**Babergh District Council and Mid Suffolk District Council (20041302)**

**Deadline 4 submission for Bramford to Twinstead (EN020002)**

The purpose of this submission is to present the councils' response in respect of the following items due at deadline 4:

STOUR VALLEY WEST SEALING END COMPOUND: PLAN VIEW  
 SCALE 1:200

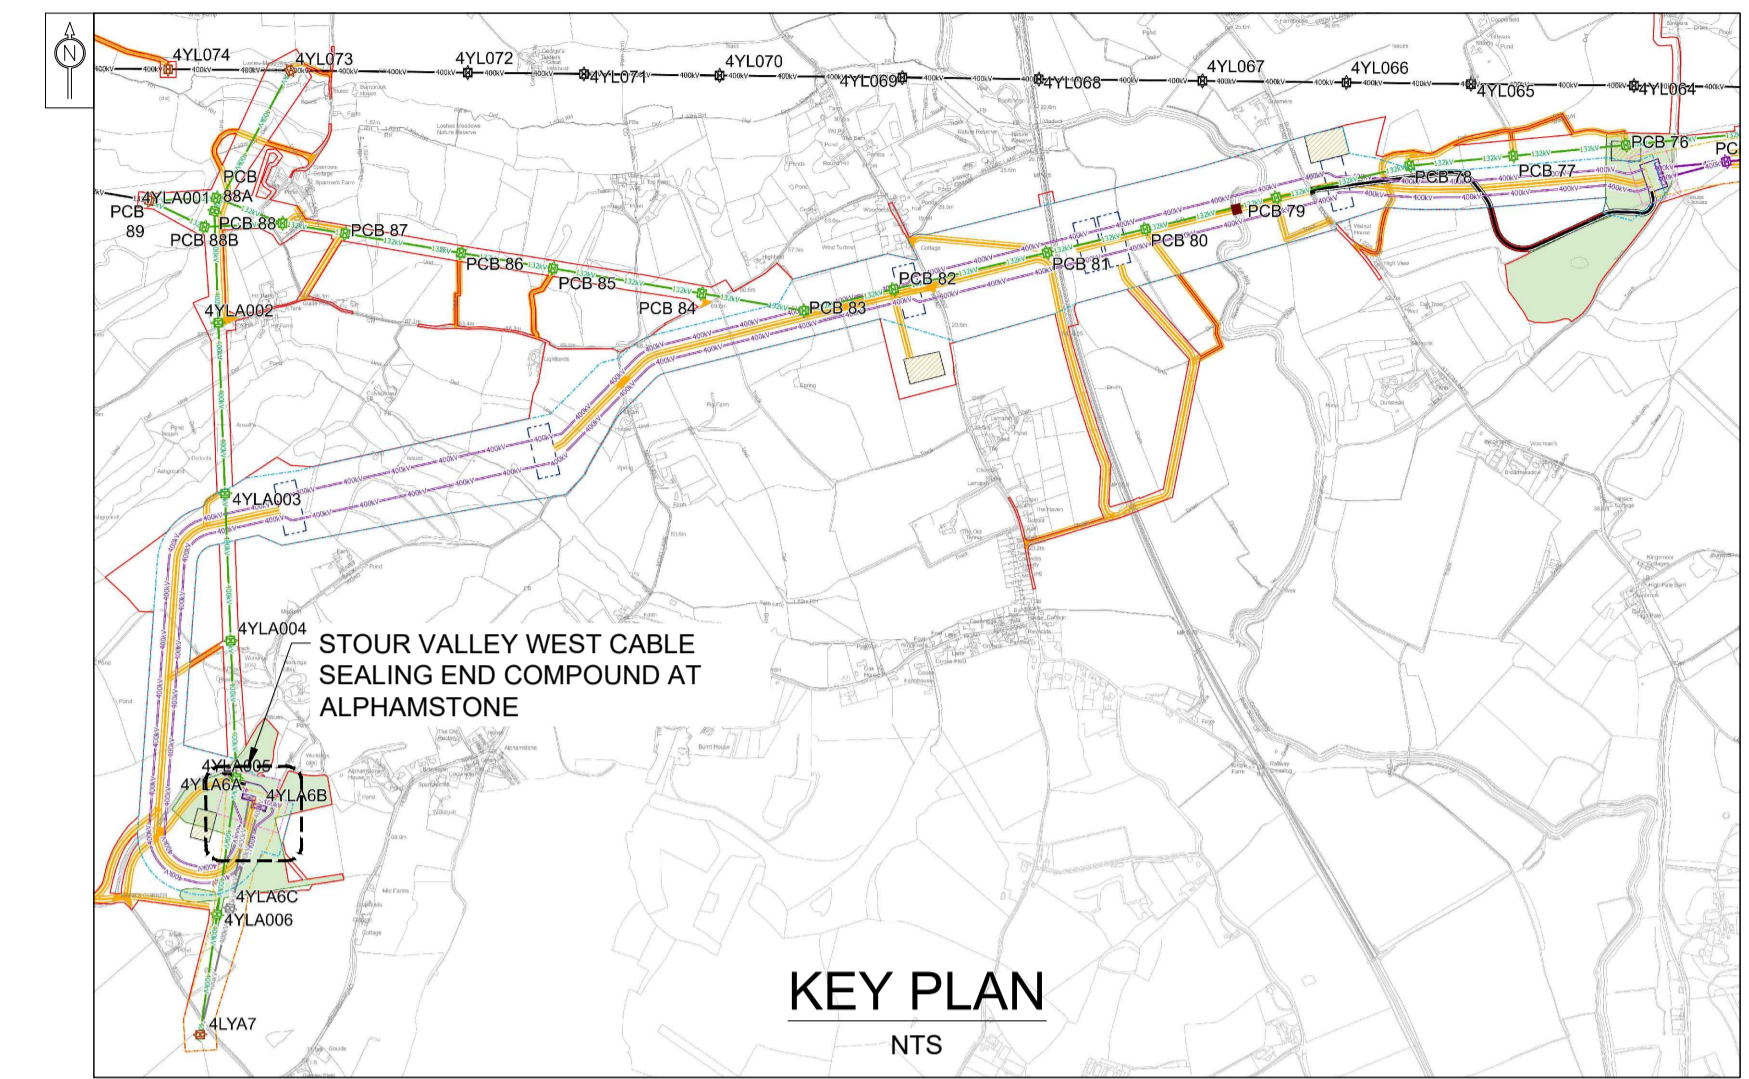
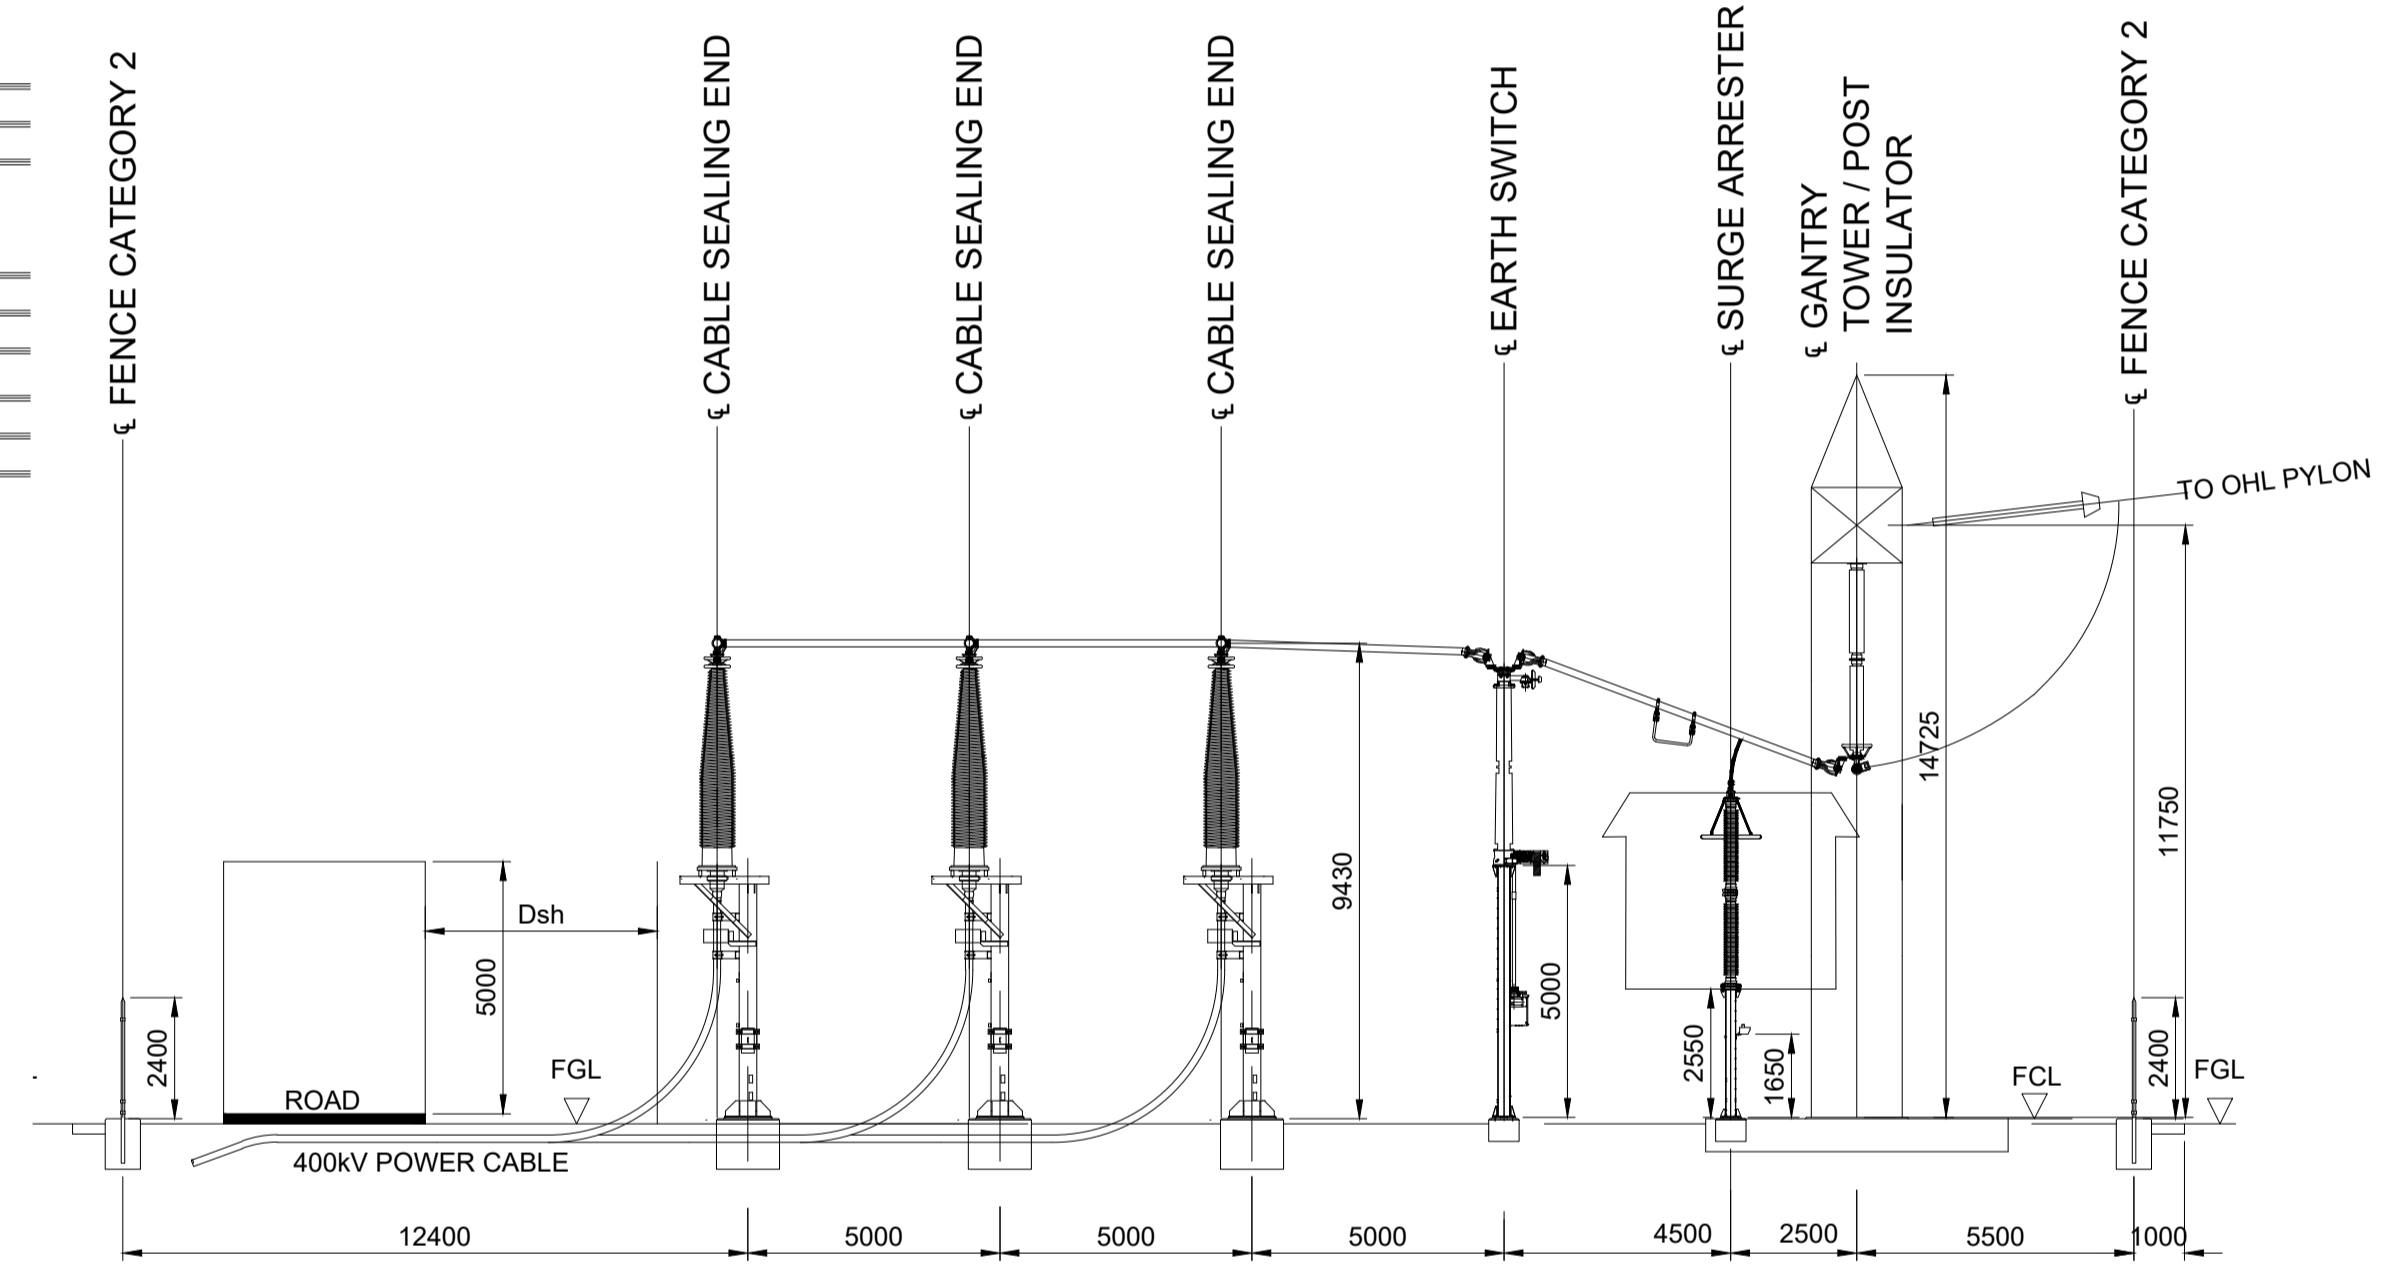
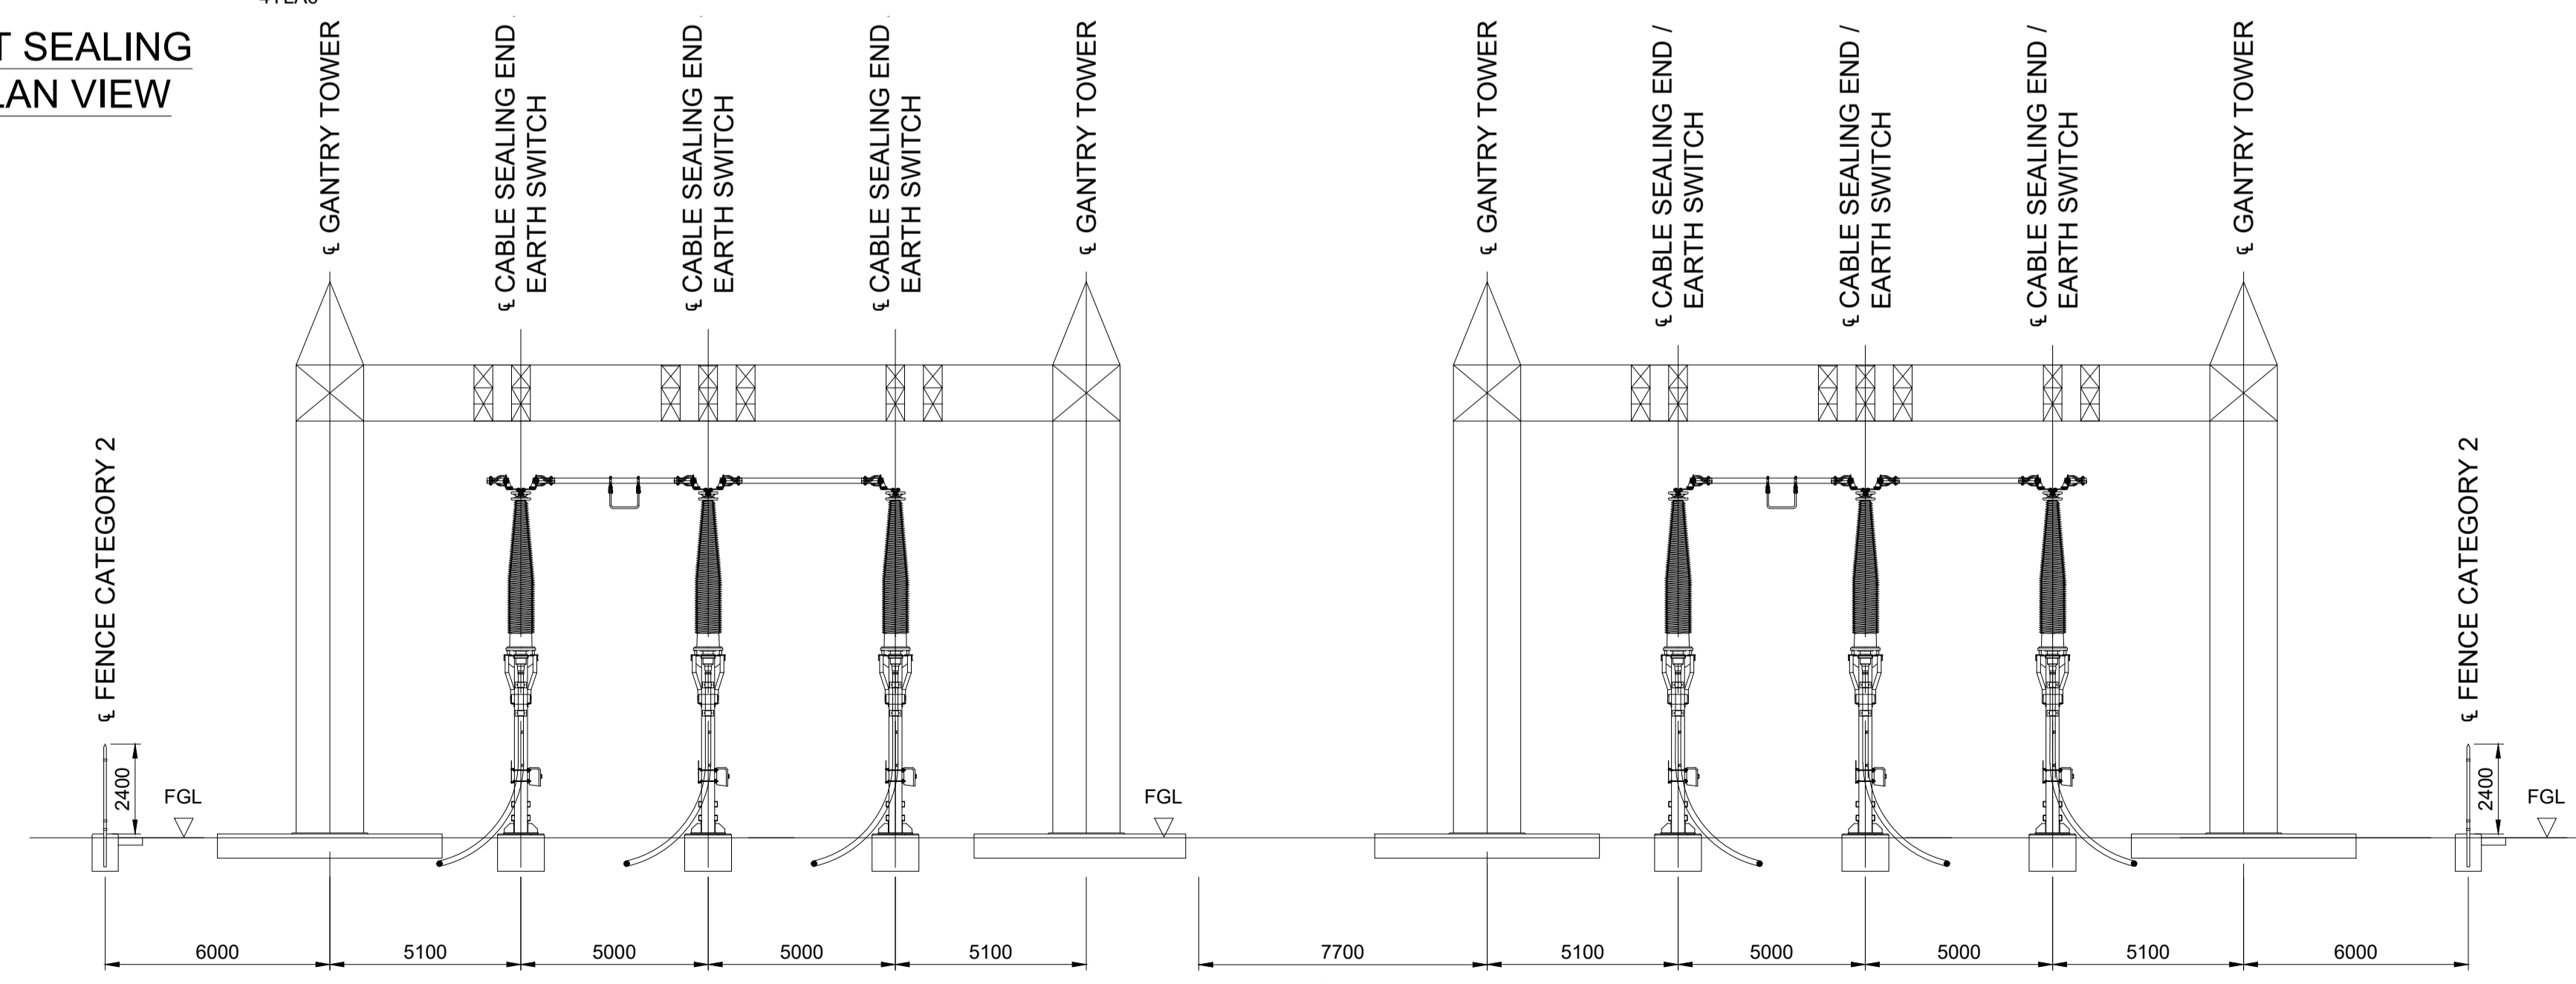
Stour Valley West compound: There are two small areas of proposed woodland to the north and southwest of the compound, some linear belts of landscape softening and large areas of proposed areas of net gain. Details of the landscape softening, and net gain do not appear to be included in the LEMP. If these land parcels do contain woodland planting, it is likely then the landscape and visual effects can be contained. However, VP G.07 Photomontage from southwest of the compound indicates that at Year 15 very little screening will have been achieved. Extensive additional mitigation planting is needed if the Year 15 image is correct.
